Contact Julia Puton
Email FRMConsultations@hertfordshire.gov.uk

Date 10 December 2019

RE: 6/2019/2714/OUTLINE – 1 YMCA, 90 Peartree Lane, Welwyn Garden City, AL7 3UL

- Drainage Strategy Report produced by Pinnacle Consulting Engineers, project number C190906, version 2.0, dated 9 October 2019.

DRAWING STATUS				
INFORMATION				
SCALE @ A1	DATE	DRAWN BY	CHECKED	
1:250	DEC '20	IL	JJ	
DRG NO.		REVISION		
C190906-PIN-XX-XX-DR-C-0210		P01

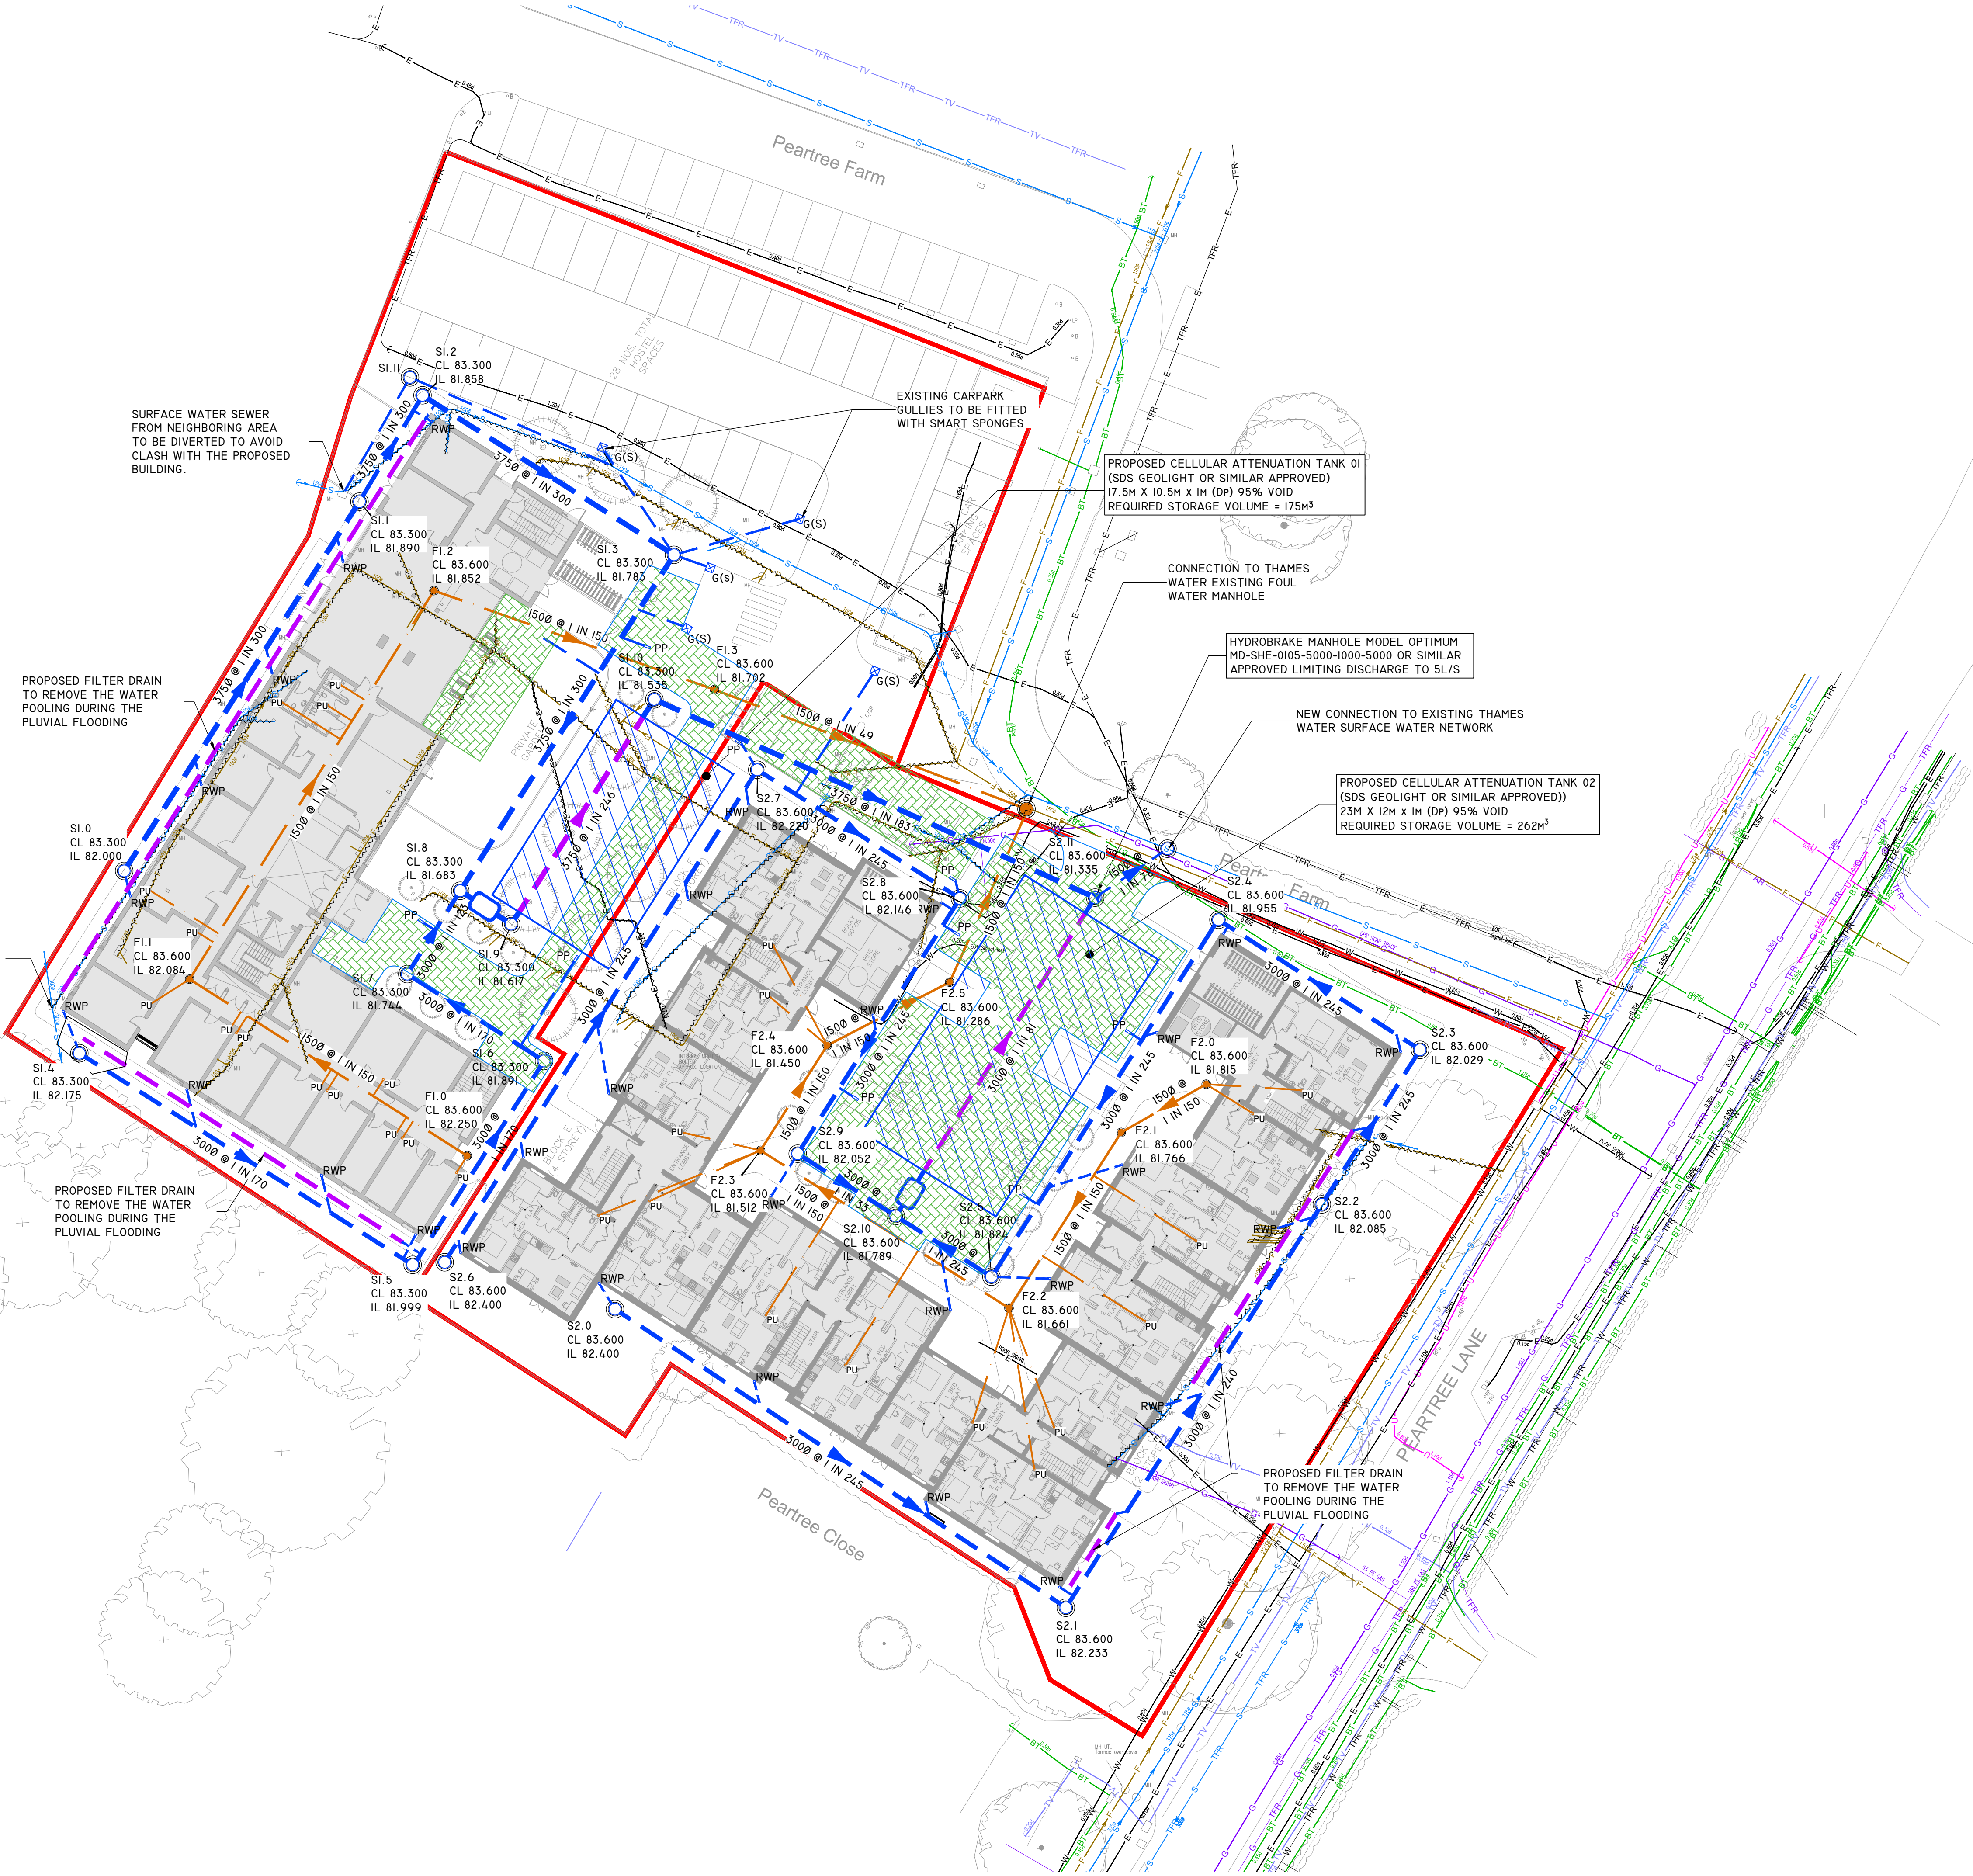
However, the entire network has been included on the proposed drainage strategy layout drawing with no additional explanation. The applicant should clarify if it is intended to keep the entire existing drainage network or not.

We would advise that the proposed discharge rates into the public sewer should be indicated on the drainage layout drawing.

8. As mentioned above, from the provided layout it is unclear how the proposed car parking area and the access will be drained. This should be clarified on the drawing.

Moreover, the proposed discharge rates into the surface water sewer should be indicated on the drawing.

It should be clarified on the drainage layout if the existing drainage network will be retained.

Moreover, we note that the applicant intends to place two major underground tank soakaways in the proposed courtyards for both development sites. We would like to remind that 5 metre buffer zone should be kept from any proposed building. We would advise that this should be indicated on the layout drawing.
